Your Ref: OWPC20448
Our Ref: BR/254/18/A 26-09-2018
Please ask for:
Amber Willard

Town & Country Planning (Control of Advertisement) (England) Regulations 2007 (as amended)

4 No. non-illuminated advertisements at various locations.

Hothamton Gardens & Surrounding areas Bognor Regis

BLOCK PLANS 1:500

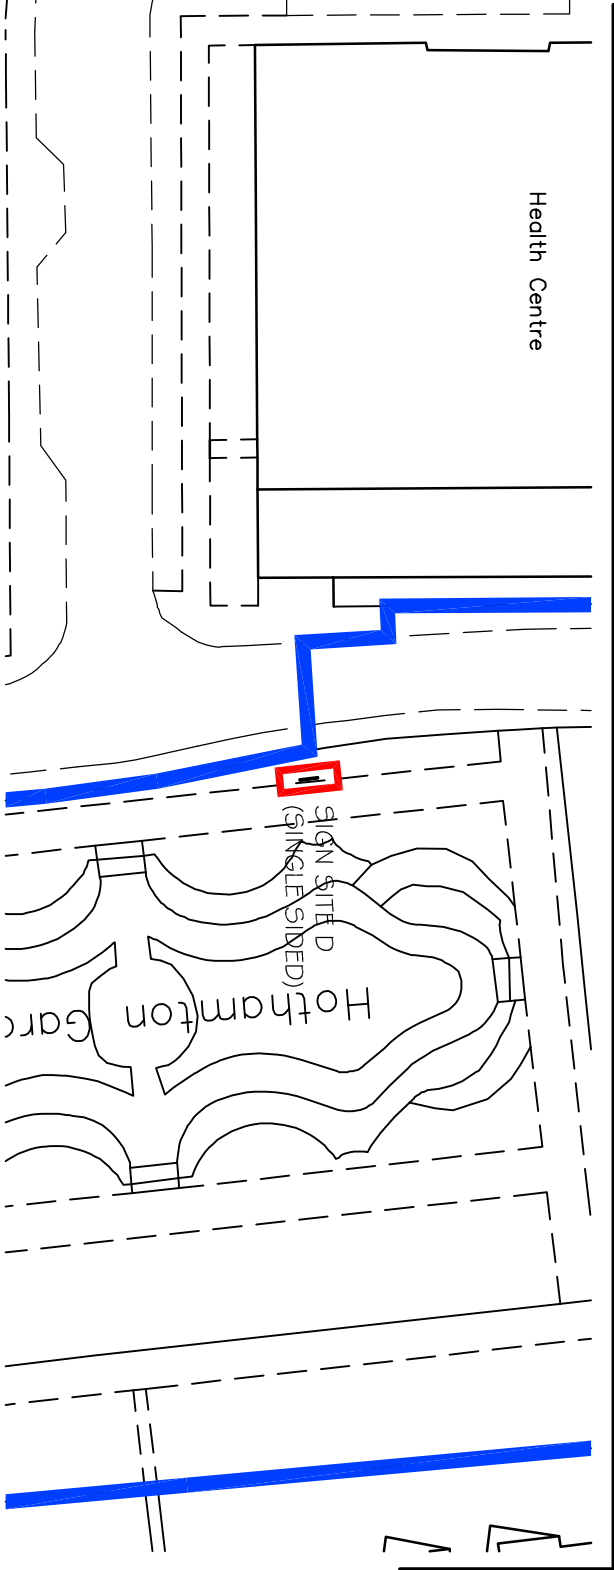
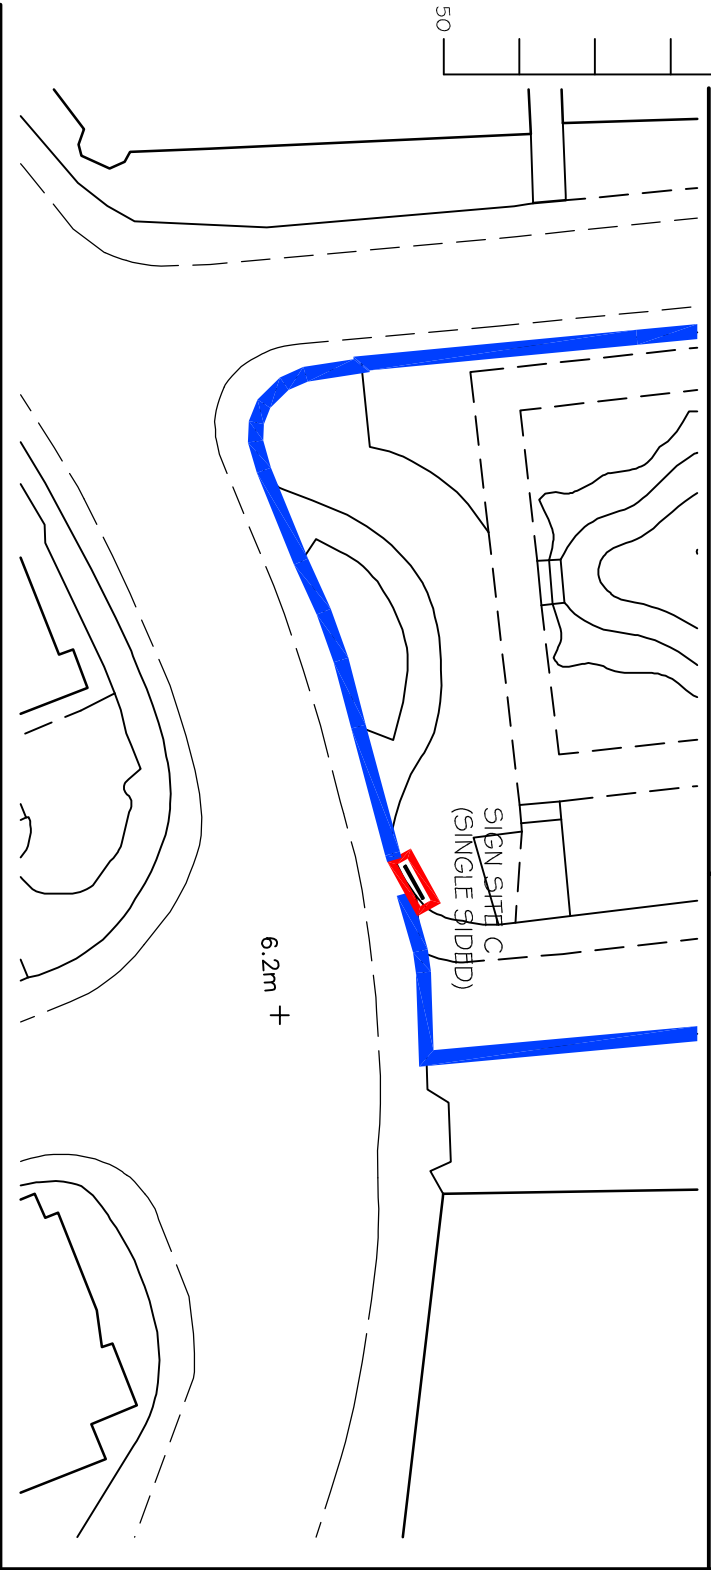
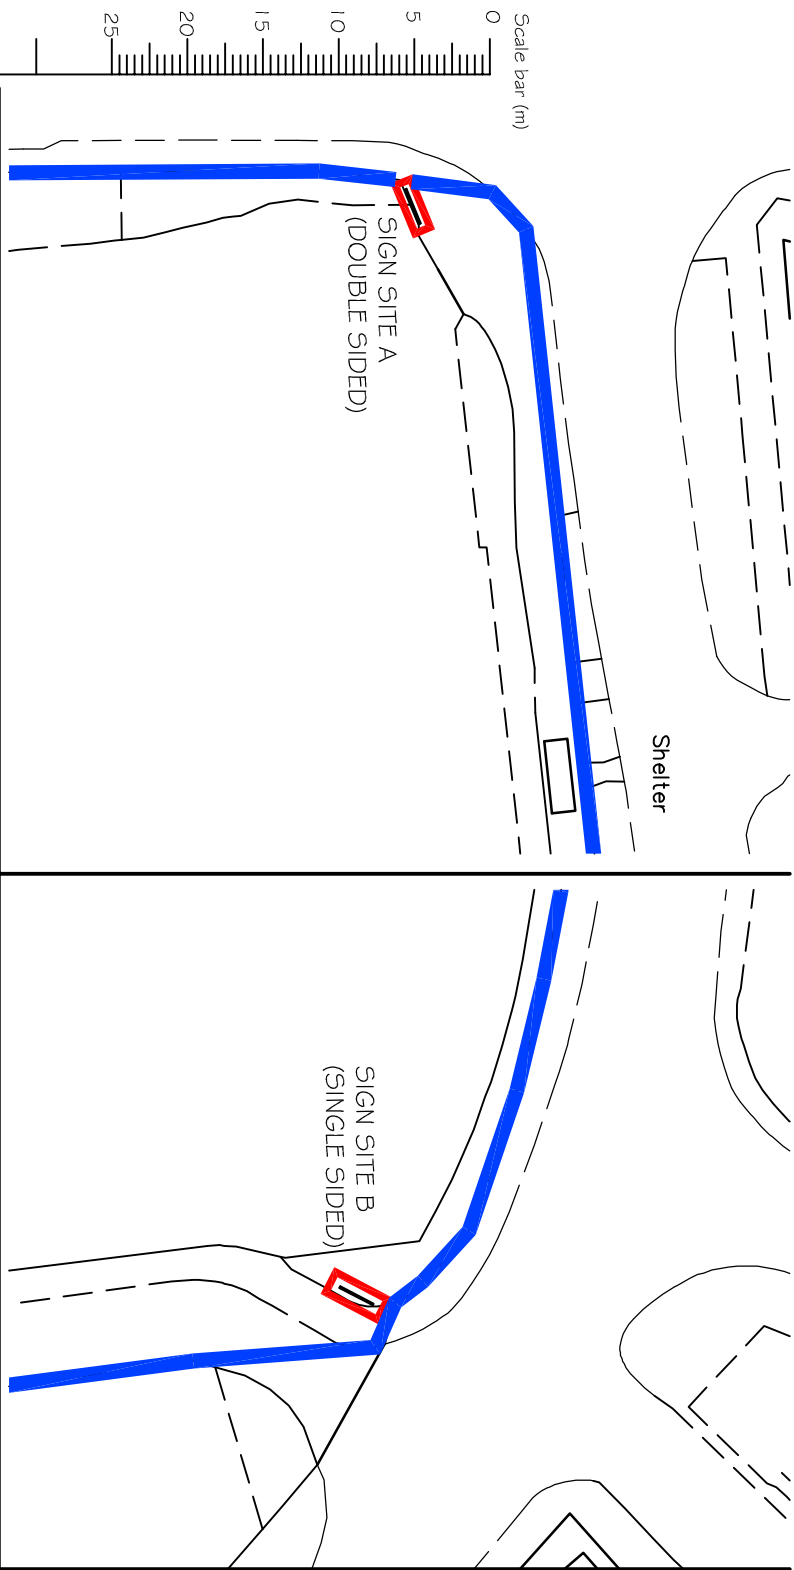
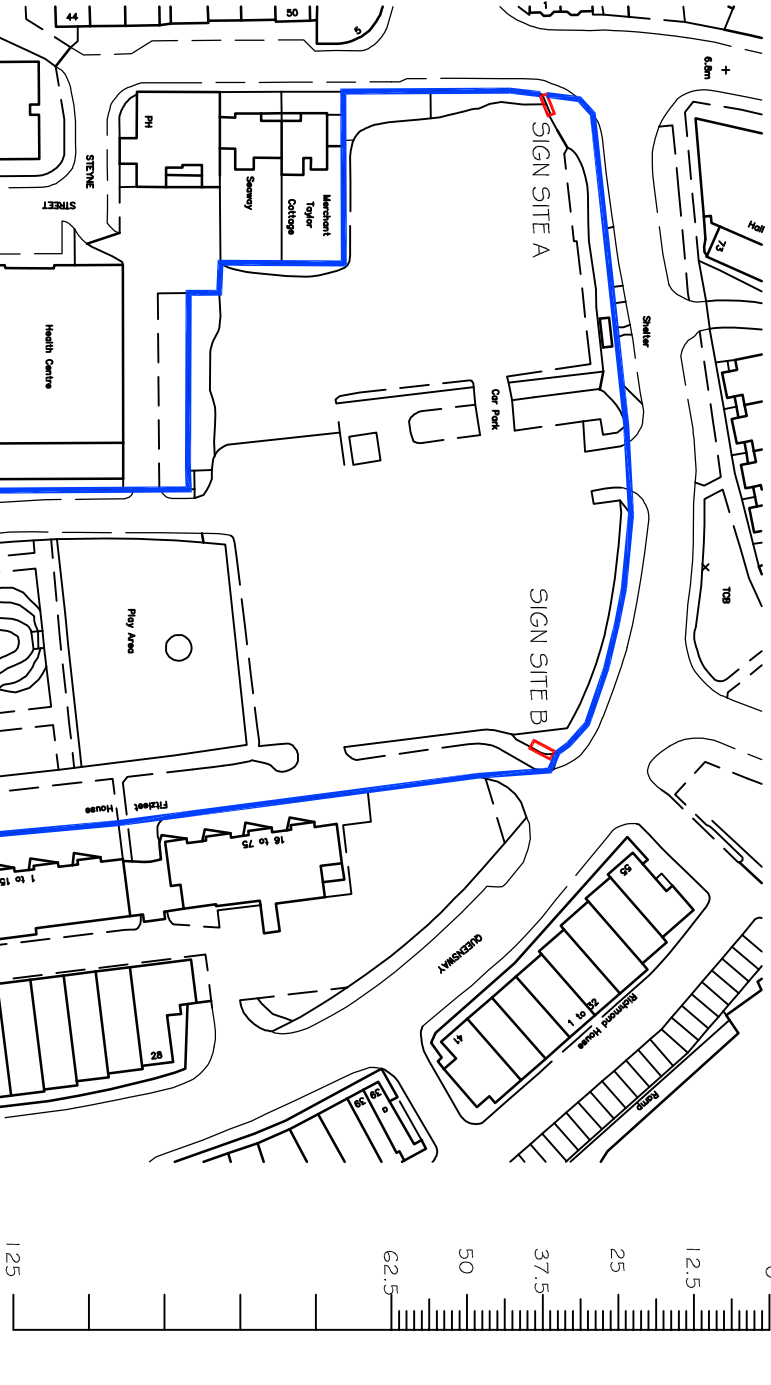
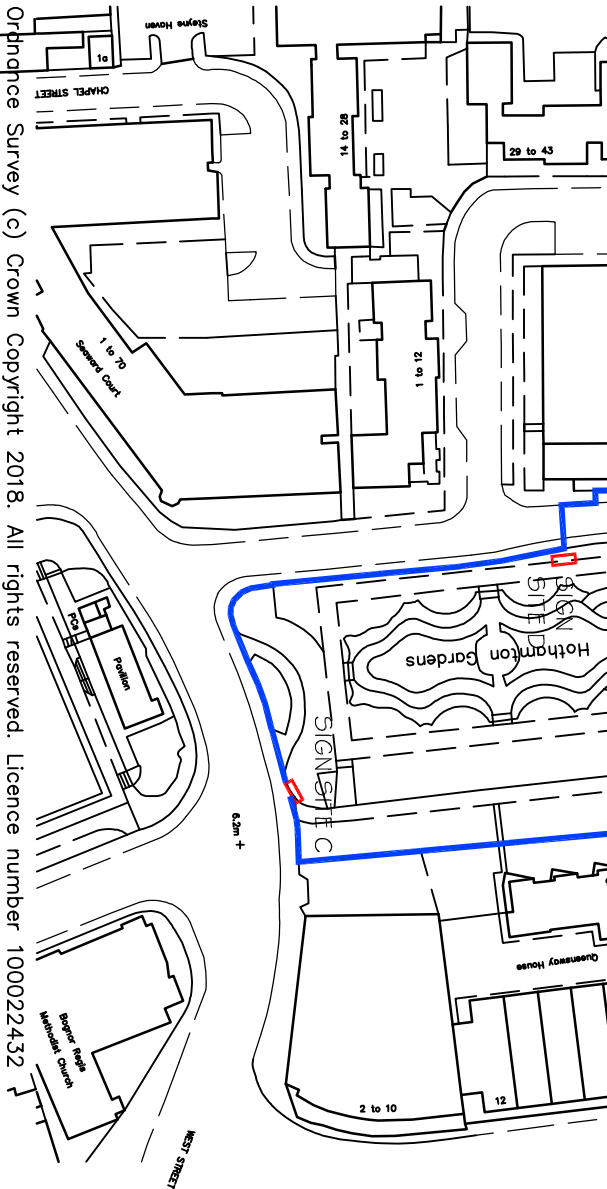
1 The Sign board to the south of the Sunken gardens would be facing a conservation area and would be clearly visible from that conservation area. This would surely be in breach of Conservation Planning Regulations

2 These boards appear to be located on the roadside. If they are intended to be readable, the detail would be such that they could be a distraction to motorists, jeopardising road safety.

3 Two of the boards are very near the gardens themselves. No checks have been carried out as to whether this may effect Birds, Bats or Owls.
